## PLANNING CONSULTATION RESPONSE

| <b>Application No</b>             | 2026/0480                                                                                                                                                    |
| <b>Proposal</b>                   | Erection of a detached bungalow and associated works including subdivision of residential garden and alterations to parking arrangements (Custom/Self-Build) |
| <b>Consultee</b>                  | Highways DC                                                                                                                                                  |

A	EXISTING AND PROPOSED SEWERS SHOWN ON PLAN. ROOF HATCH UPDATED FOR PROPOSED PLOT.	29.07.26
REV	DESCRIPTION	DATE
DEVELOPMENT		
LAND ADJACENT TO 66 LONGLEY STREET, BARUGH GREEN		
DRAWING TITLE		
PROPOSED SITE LAYOUT		
DATE	25.04.26	SCALE 1:250@A3
DRAWN	WS	
DRAWING REF	LS-NB-PSL-01	REV A

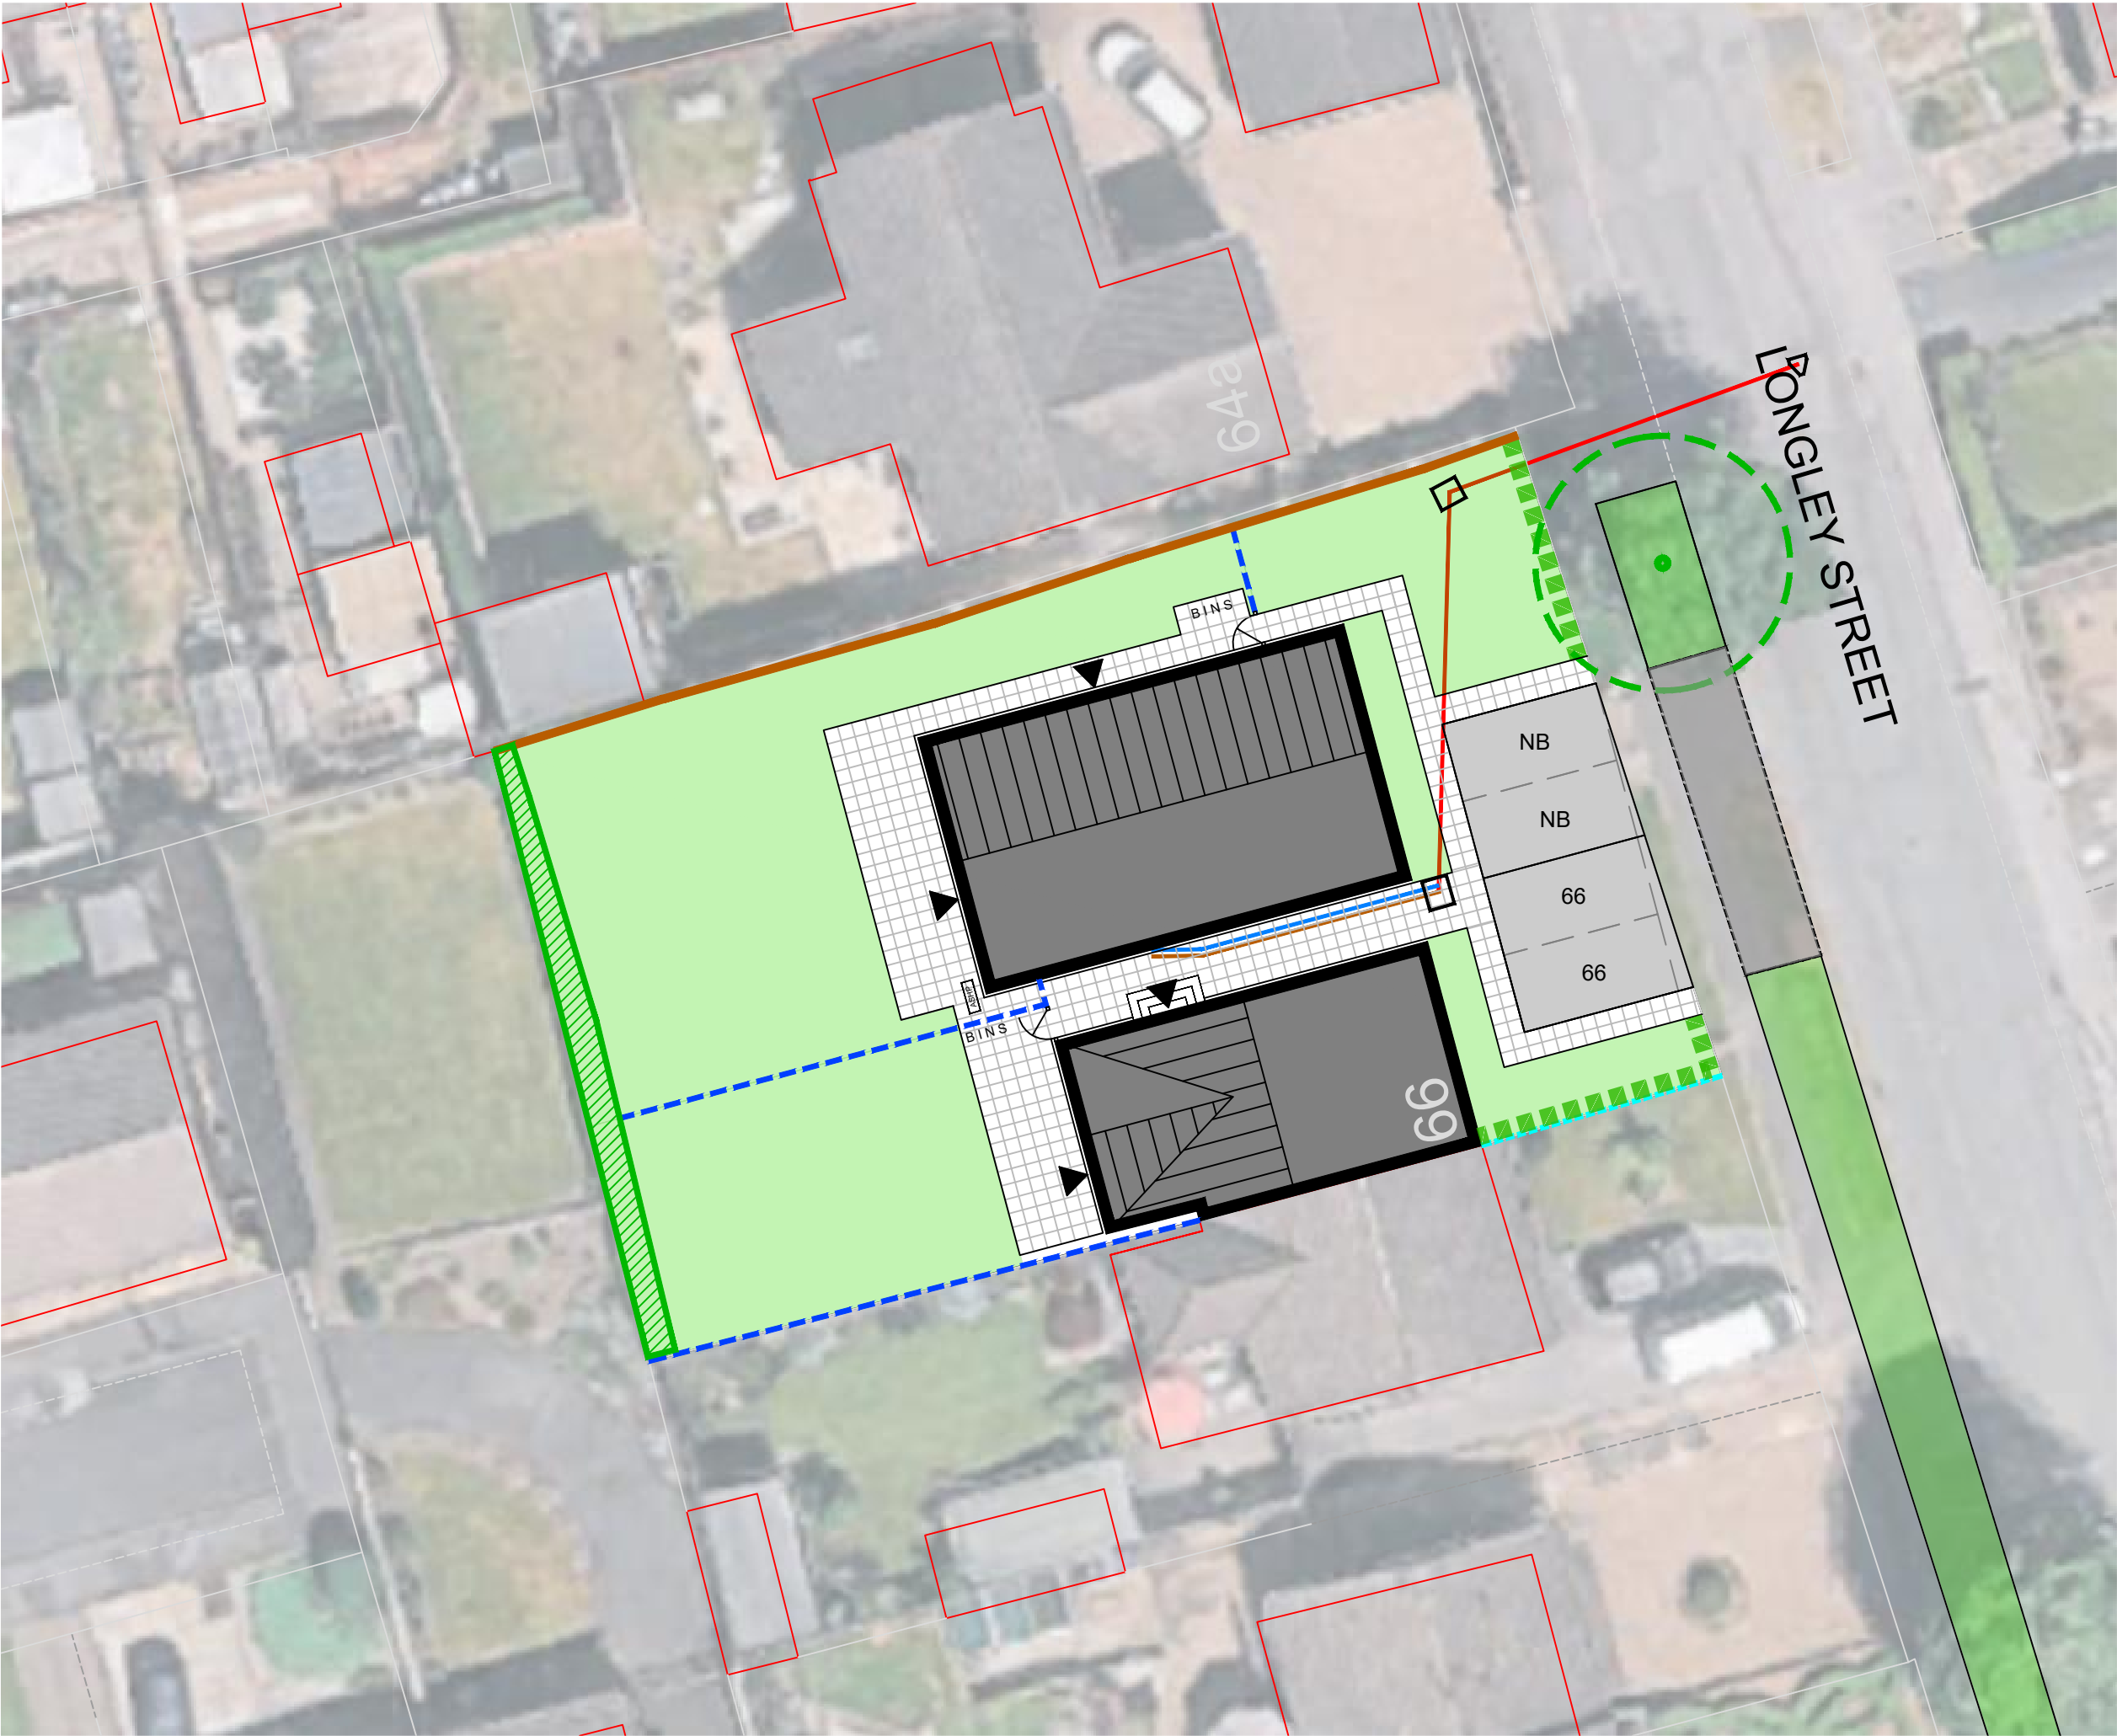
The subject site is currently extended garden area to the side of the existing host dwelling. Drawing no. LS-NB-PSL-01 shows a widened driveway providing two off-street parking spaces for 66 Longley Street, and two off-street spaces for the proposed new dwelling. Bin storage is also shown on the layout plan.

Given adequate parking and refuse storage is provided for each property, HDC officers would have no wish to raise objection to the scheme. However, as there are changes to the parking provision, the below conditions should be included in the decision notice.

The parking facilities as indicated on the submitted plan shall be surfaced in a solid bound permeable material (i.e. not loose chippings) and adequate measures shall be so designed into the proposed access to avoid the discharge of surface water from the site on to the highway.

The gradient of the vehicular access/driveway shall not exceed 1 in 12 as measured from the edge of adjacent carriageway.

The parking facility hereby permitted shall not be brought into use until pedestrian visibility splays of 2m x 2m to the back edge of the footway have been provided at the proposed access. Nothing shall be erected, retained, planted and/or allowed to grow at or above a height of 0.6m to the rear of the footway which would obstruct the visibility splays. The visibility splays shall be maintained free of obstruction at all times thereafter for the lifetime of the development.
